November 2, 2012

**Subject: Hotel Conversion – Former Gannett Building
119 Exchange Street
Preliminary Site Plan Application
Applicant: 119 Development LLC**

On behalf of 119 Development LLC, we are pleased to provide the following supplemental information related to the proposed hotel redevelopment of the former Gannett Building at 119 Exchange Street (former primary address was 390 Congress Street). Specifically, we have reviewed the Planning Board Memorandum dated October 25, 2012 and offer various responses to comments and information contained in the memorandum.

TREE PLANTER DETAIL
N.T.S.

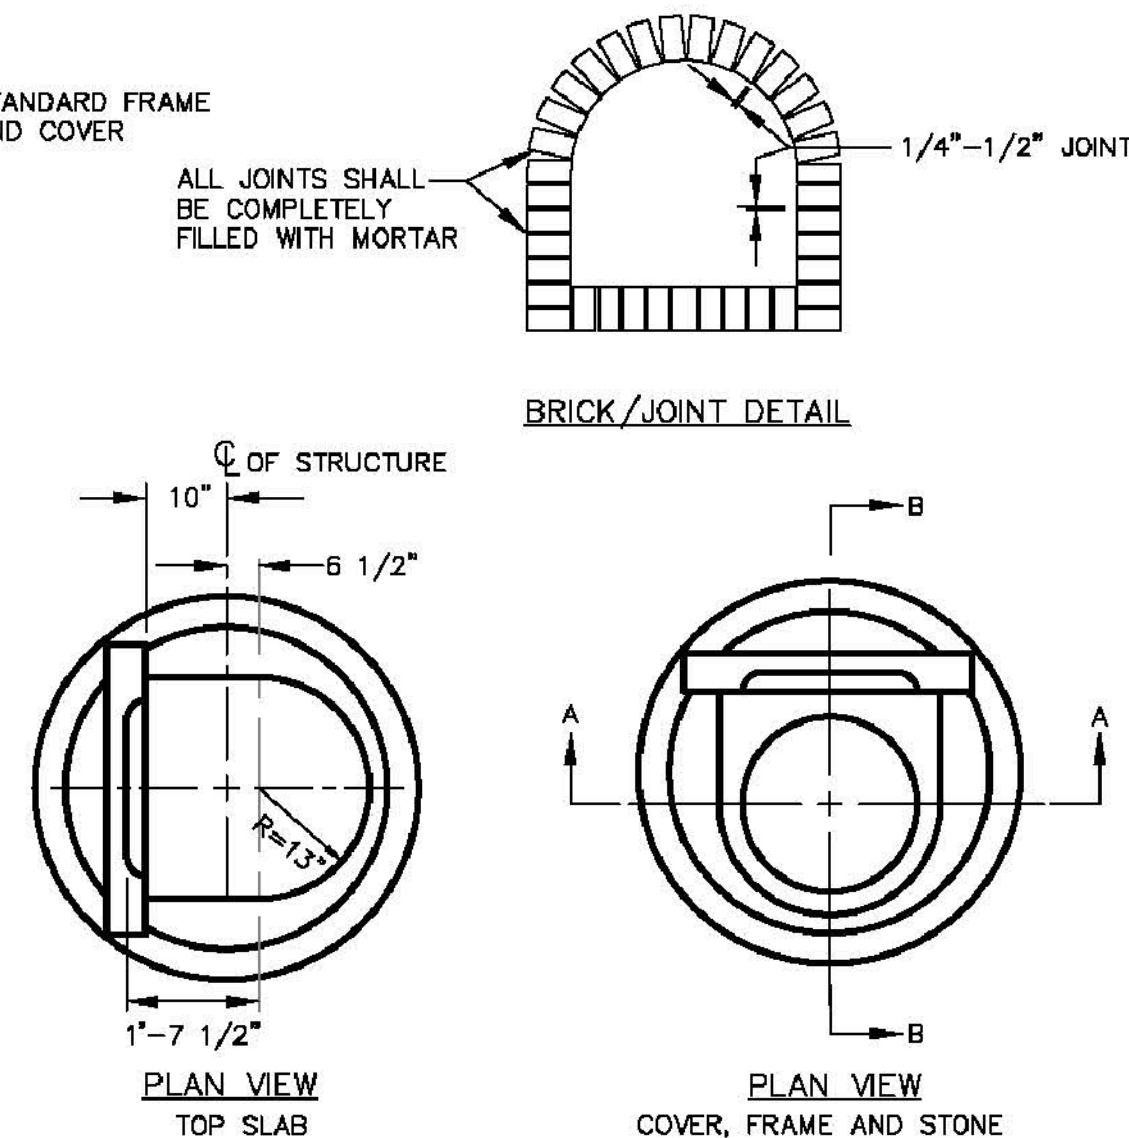
cannot support trees due to the basement space below the sidewalks as well as the canopy overhang along Congress Street. The applicant is seeking to retain the existing street trees, as is, while proposing to install four trees along Federal Street within the proposed sidewalk extension. No plantings are proposed within the Exchange Street sidewalk extension at the Hotel Entrance. The applicant is not proposing landscaping in the 385 Congress Street parking lot, which is not the applicant's lot, hence a waiver of these requirements is requested.

BRICK SIDEWALK WITH BITUMINOUS BASE
N.T.S.

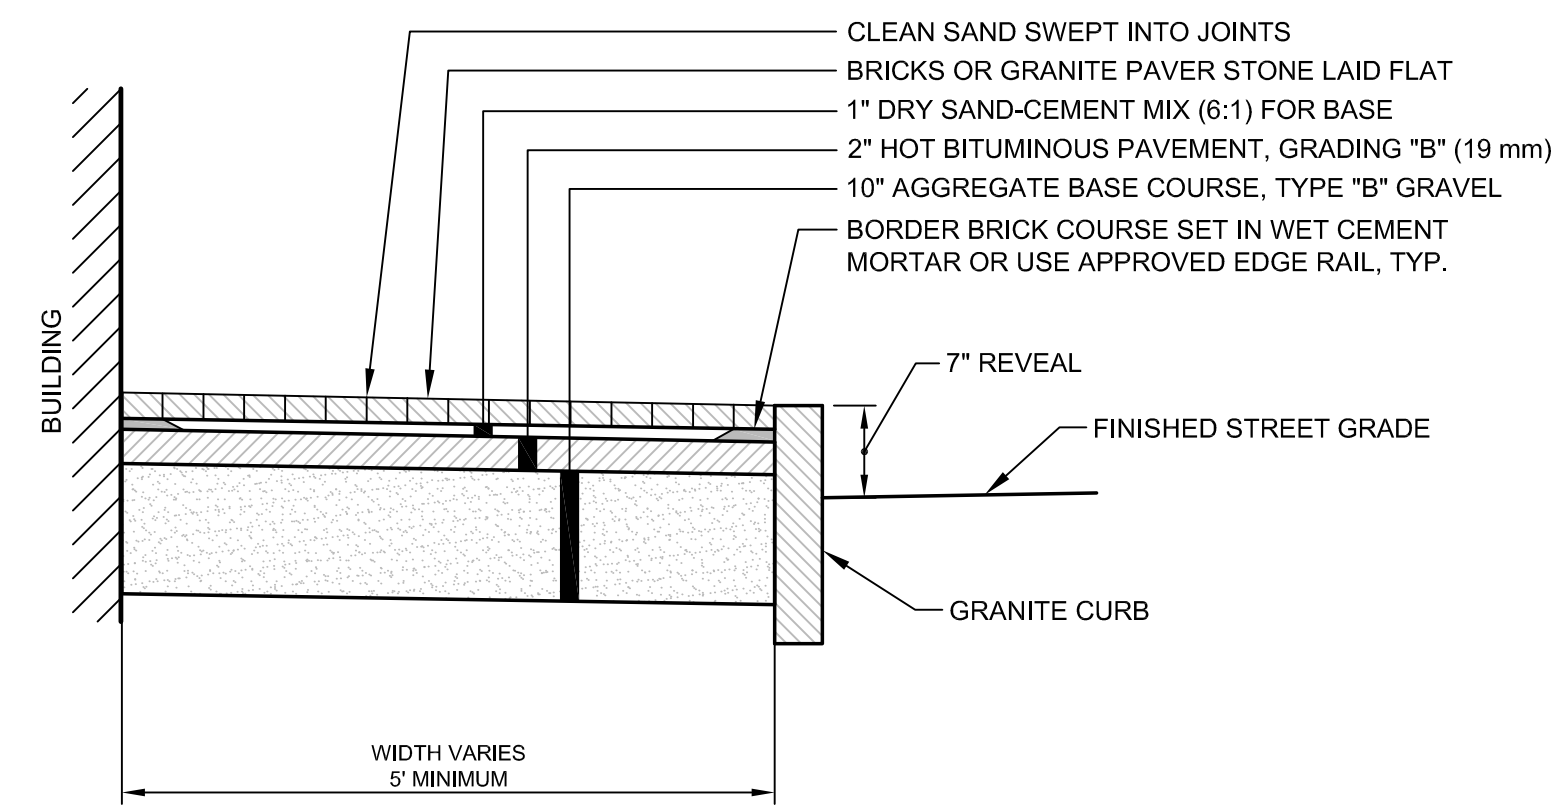
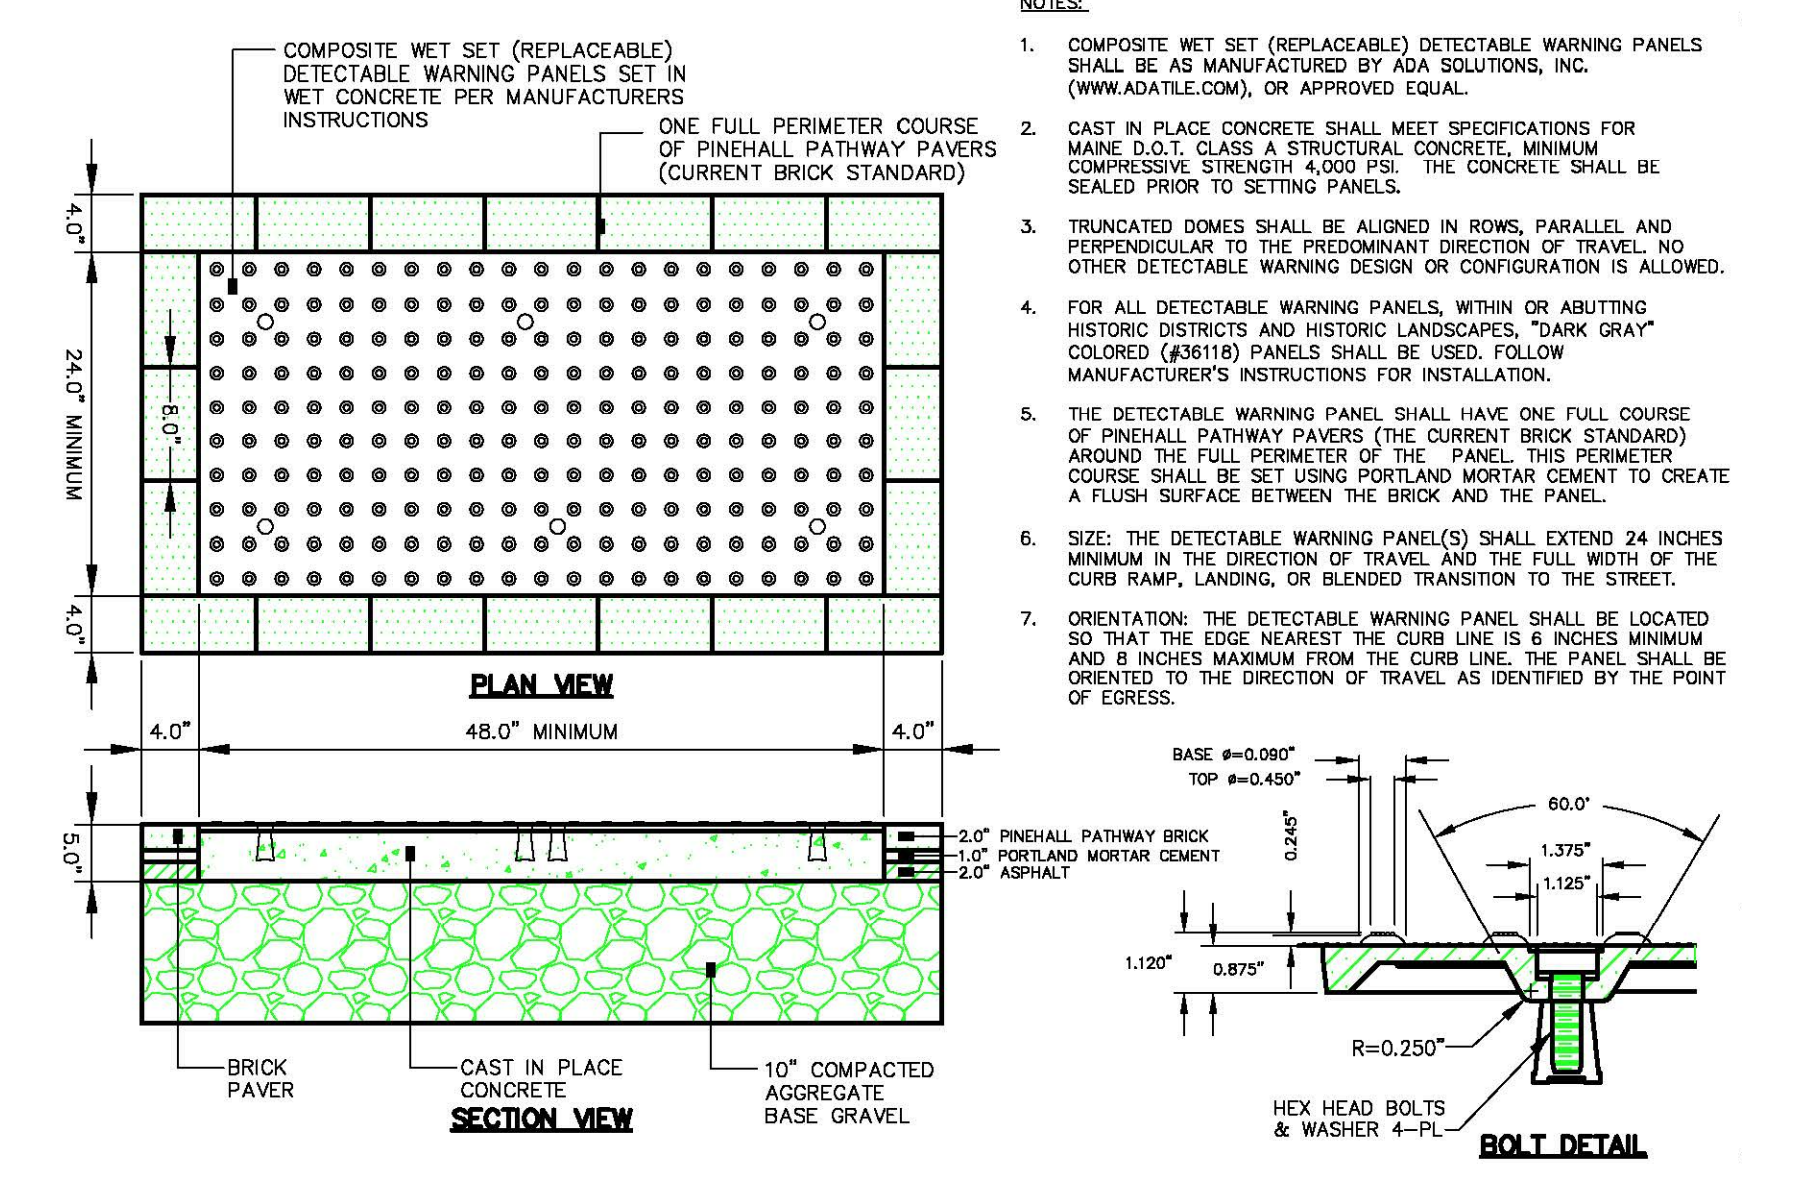
The portion of existing brick sidewalk that is over basement space will be reconstructed as part of a waterproofing effort on the concrete slab and walls. Much of the remaining brick sidewalk around the building is in reasonable condition, some areas of which have recently been reconstructed, and does not appear to warrant full reconstruction. The Applicant is amenable to review and possible reconstruction of the sidewalk ramps on Congress Street if necessary.

BICYCLE PARKING RACK PLACEMENT
N.T.S.

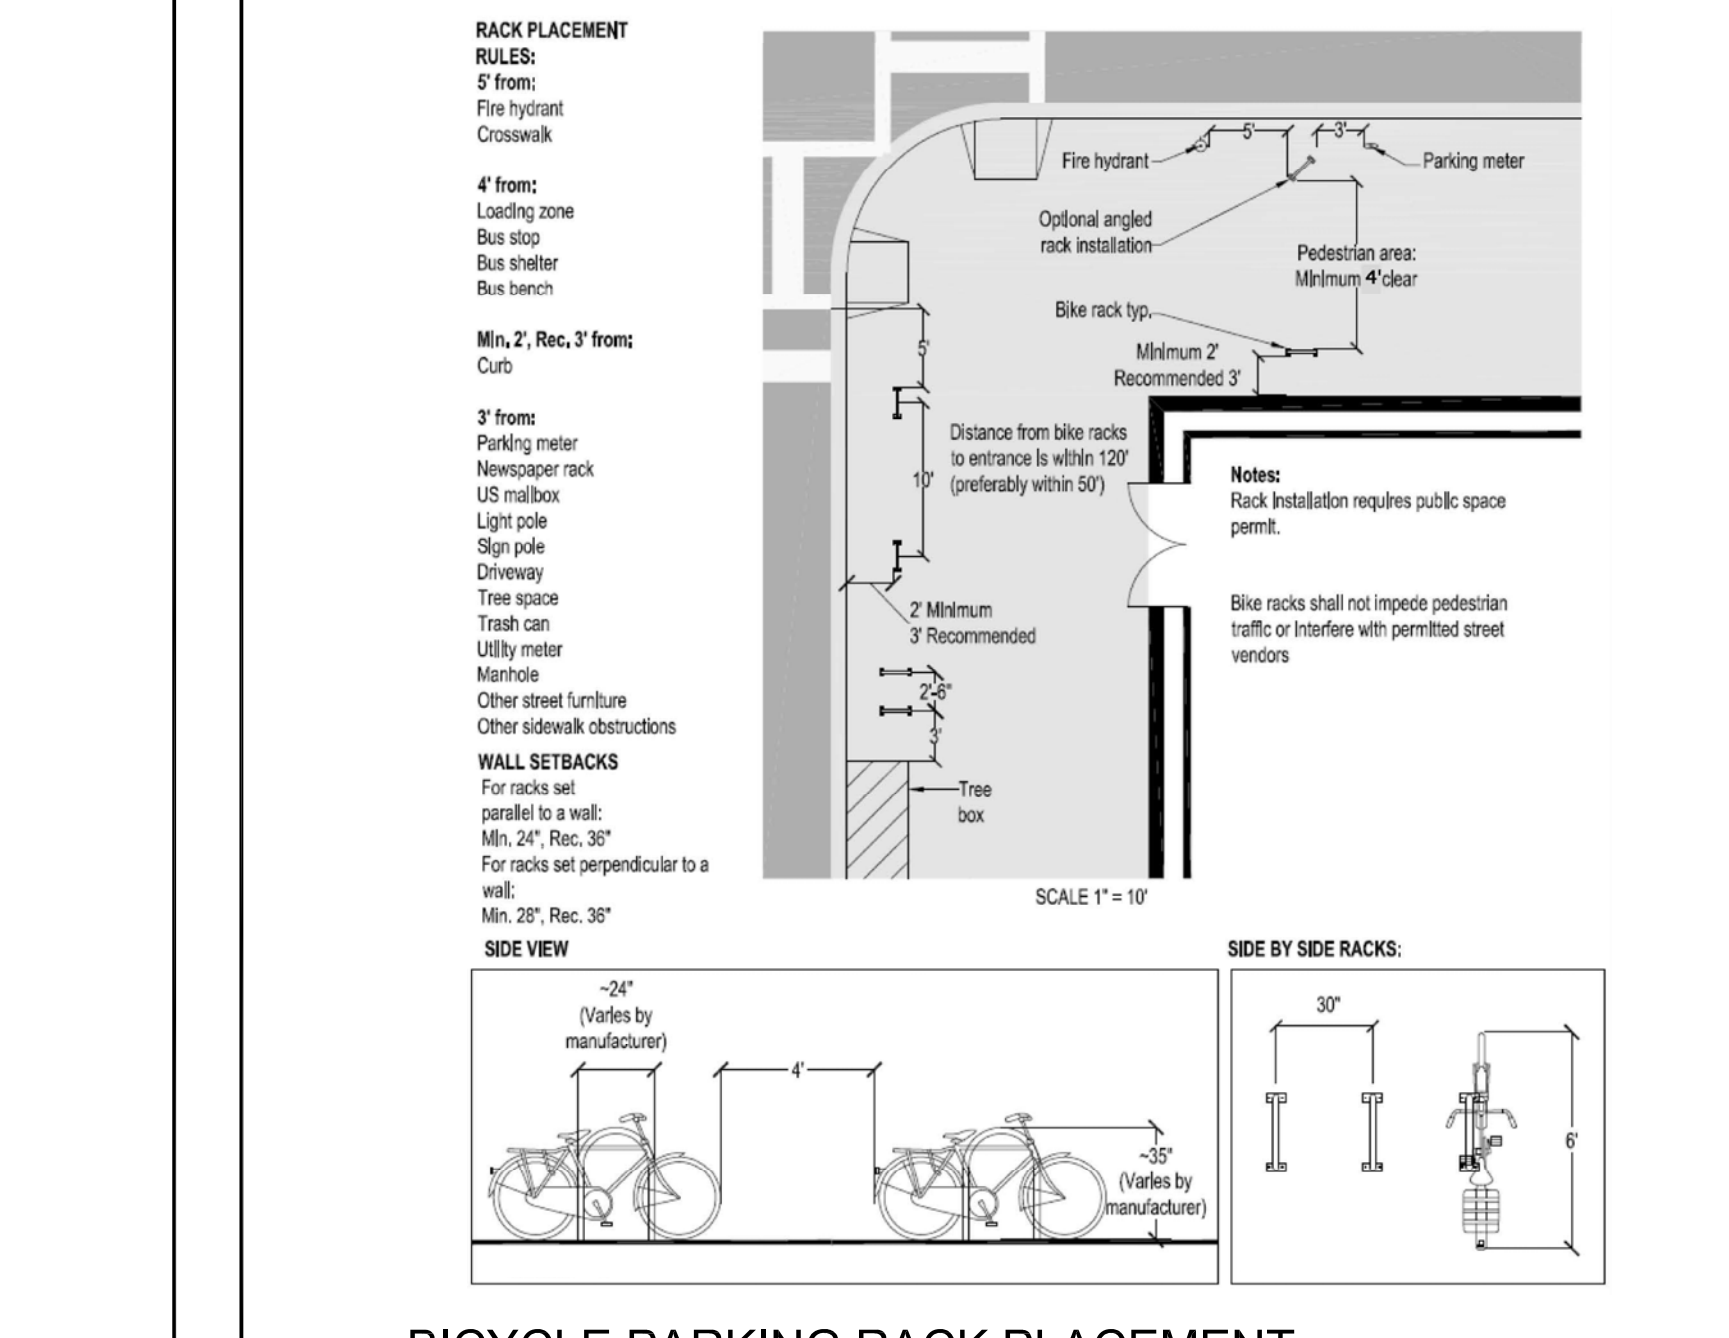
Regarding the bicycle parking requirements, the applicant is amenable to providing additional bicycle racks along the site's adjacent sidewalks. We propose to install the racks along Federal Street and Market Street in order to provide a total of ten bicycle spaces. We are interested in discussing options for the type of racks to be installed, as there may be alternative styles that may blend more pleasingly with the hotel motif, etc. A waiver request will not be required.
